Memorandum

Re: BL-17-00006 IOOF BLA Comments

The following are the Energy Services Light Department comments for the proposed boundary line adjustment application affecting parcels 503634, 513634, 744134 and 474134.

IOOF LODGE NO. 20 PROP.

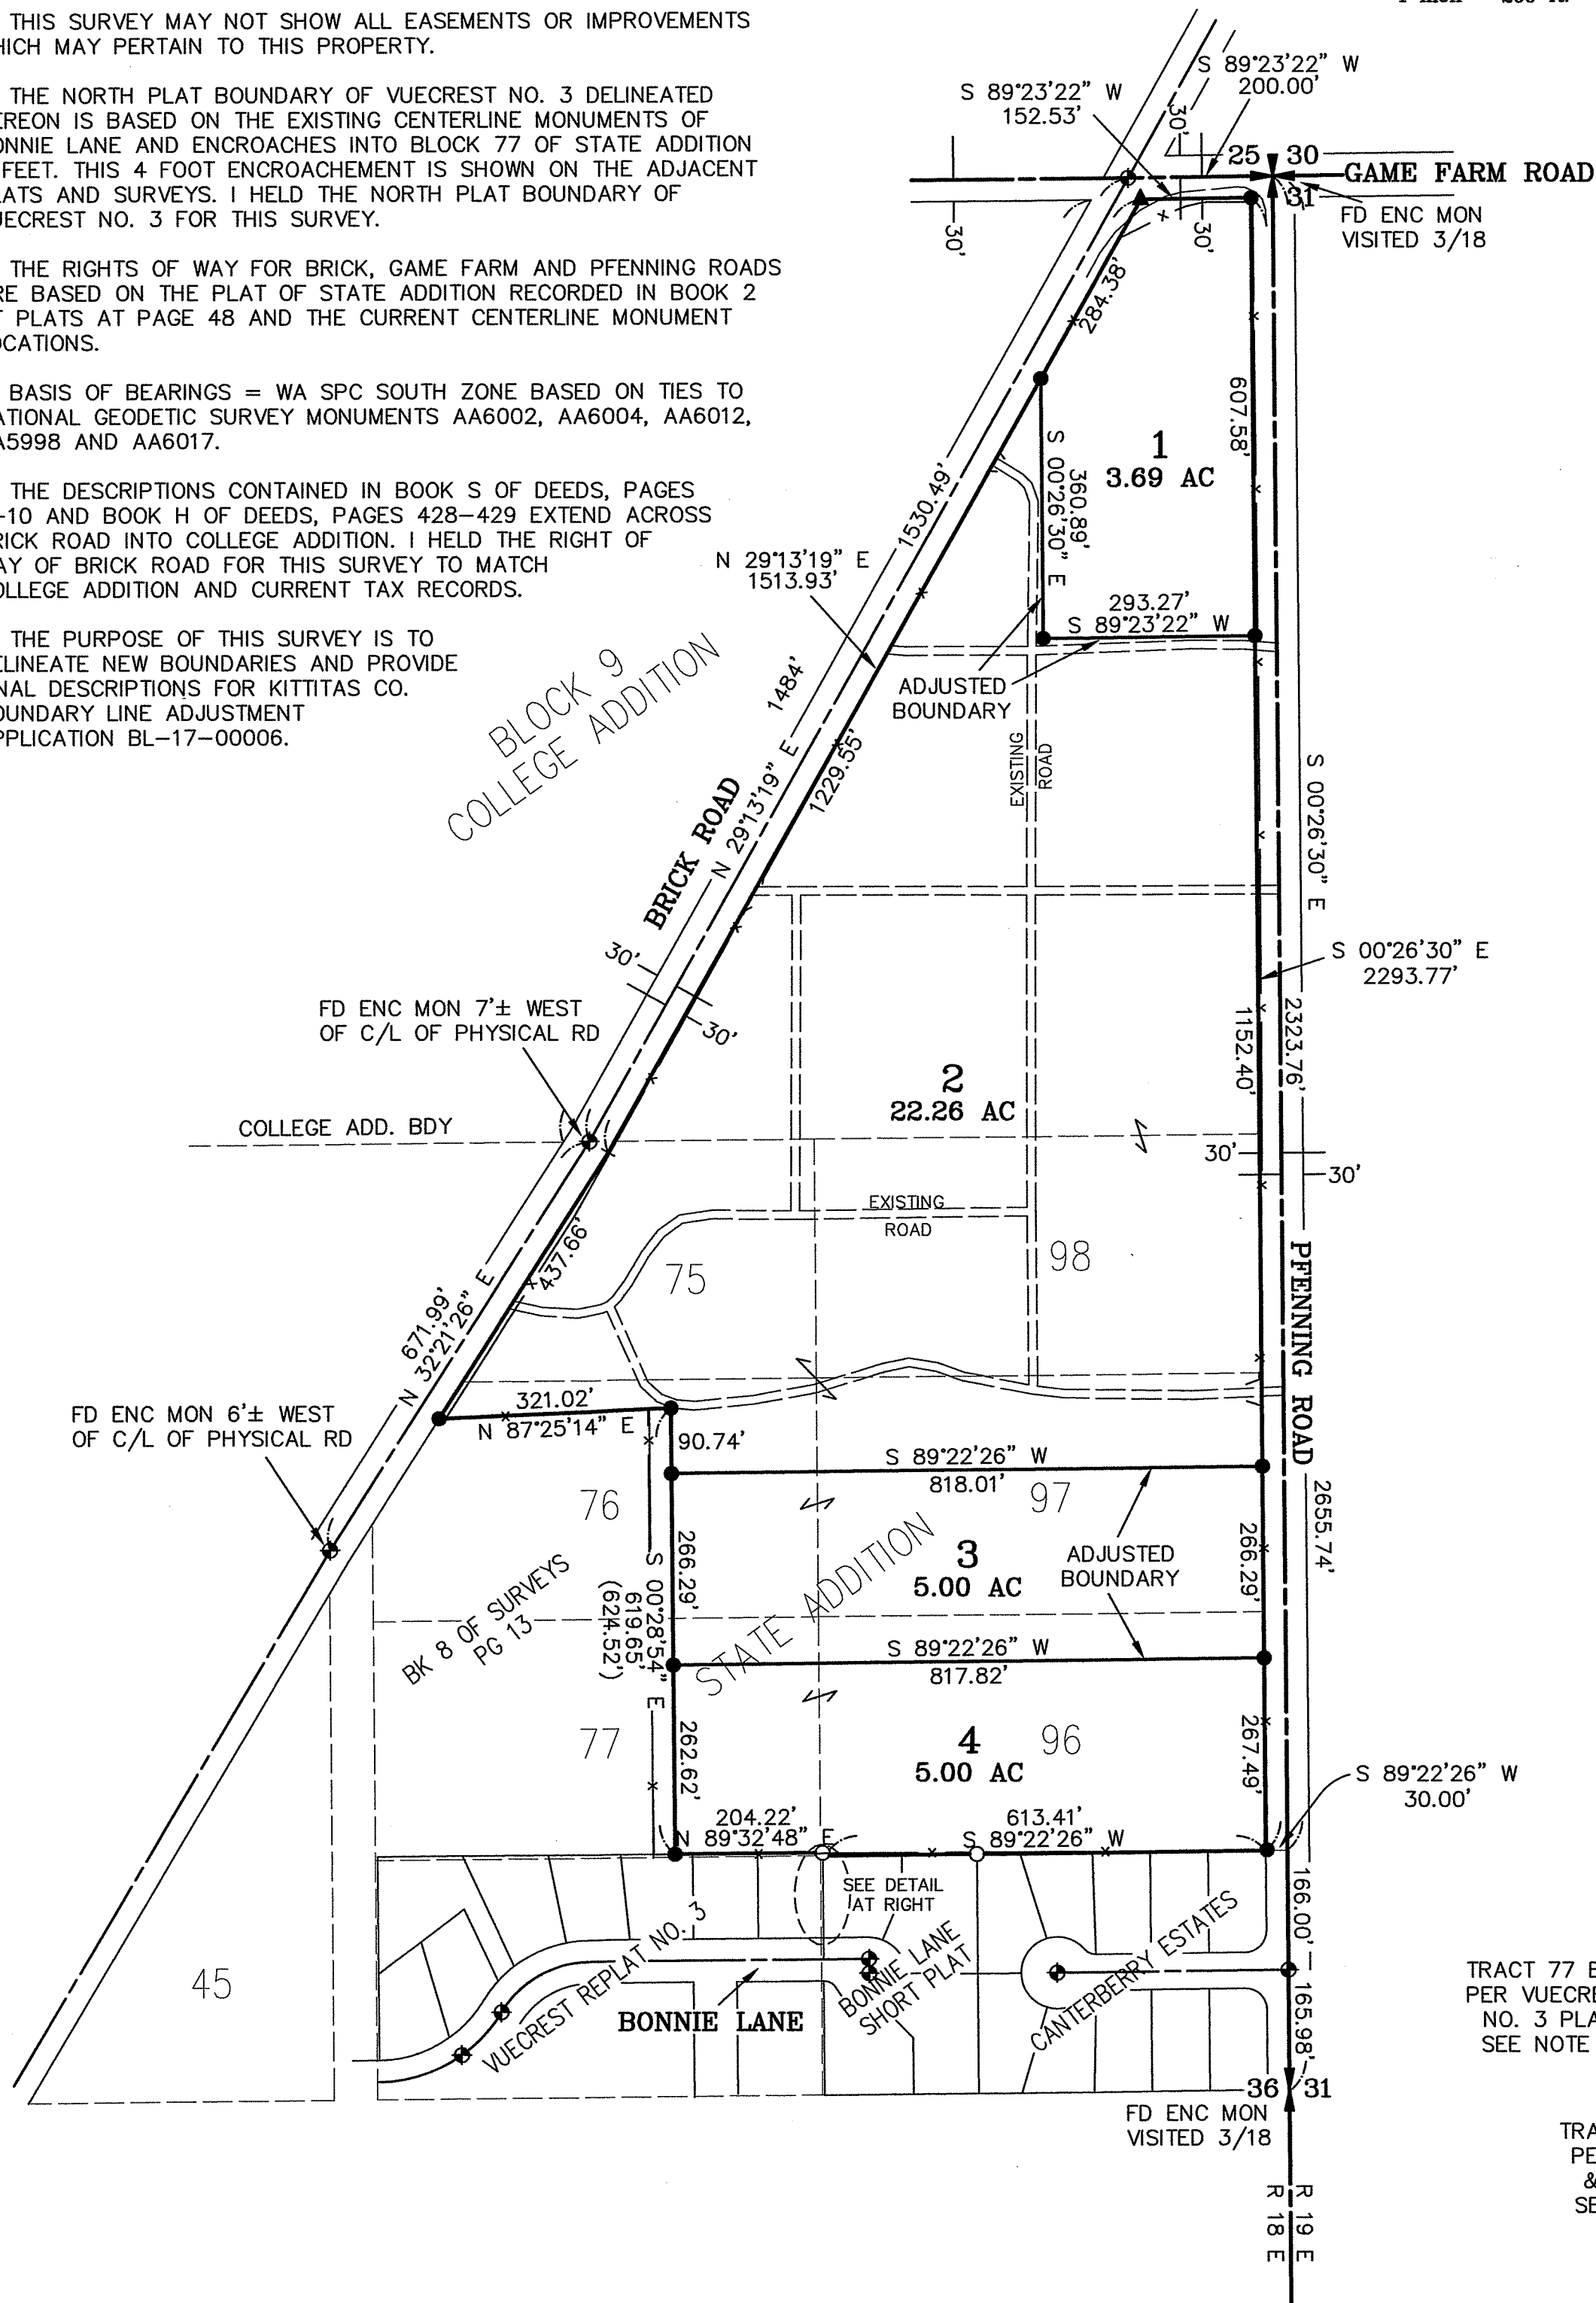
The City of Ellensburg has existing underground primary facilities which appear to run in an easement through existing parcels 744134 and 474134 on the south side of the office building, originating at a pole on Pfenning Road and cutting over near Brick Road to the neighboring church building. While these facilities are not shown on the drawings submitted, it appears that they will be on resultant parcel 513634 once the BLA is complete.
